Our ref: DOC22/999275  
Your Ref: SSD-35283699

7 December 2022

### **Subject: EHG Comments on the Environmental Impact Statement for the Sydney Olympic Park Metro Station - Over and Adjacent Station Development Concept (SSD-35283699)**

Figure 2-2 Proposed Concept SSDA development and CSSI scope

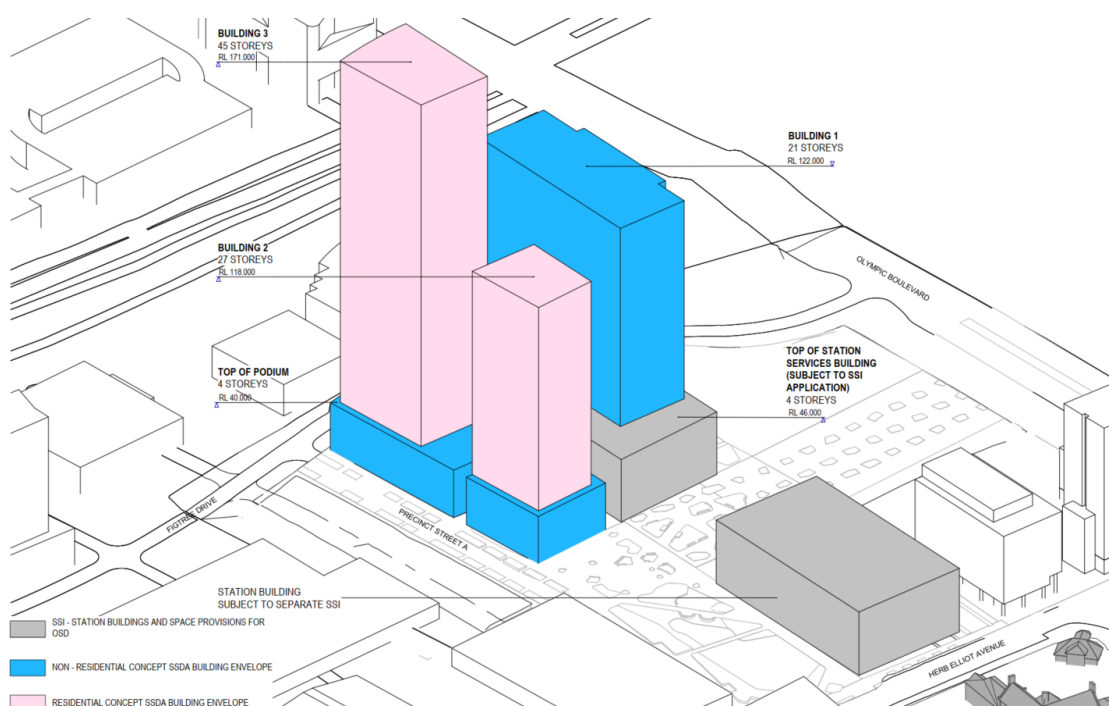
The modelling shows flooding in a PMF event in Figtree Drive at the east of the site, at the intersection with Precinct Street A. The modelling indicates depths of 0.1-0.2m and 0.2-0.3m, which would limit access to and evacuation from Precinct Street A. EHG recommends that the main driveway entry be in Figtree Drive, to the west of this flooding to enable access in all flood events.

EHG further recommends consultation with the SES regarding emergency management. If Precinct Street A is used as the main vehicular access, Buildings 2 and 3 will not have flood free access in all flood events, contrary to the reporting.
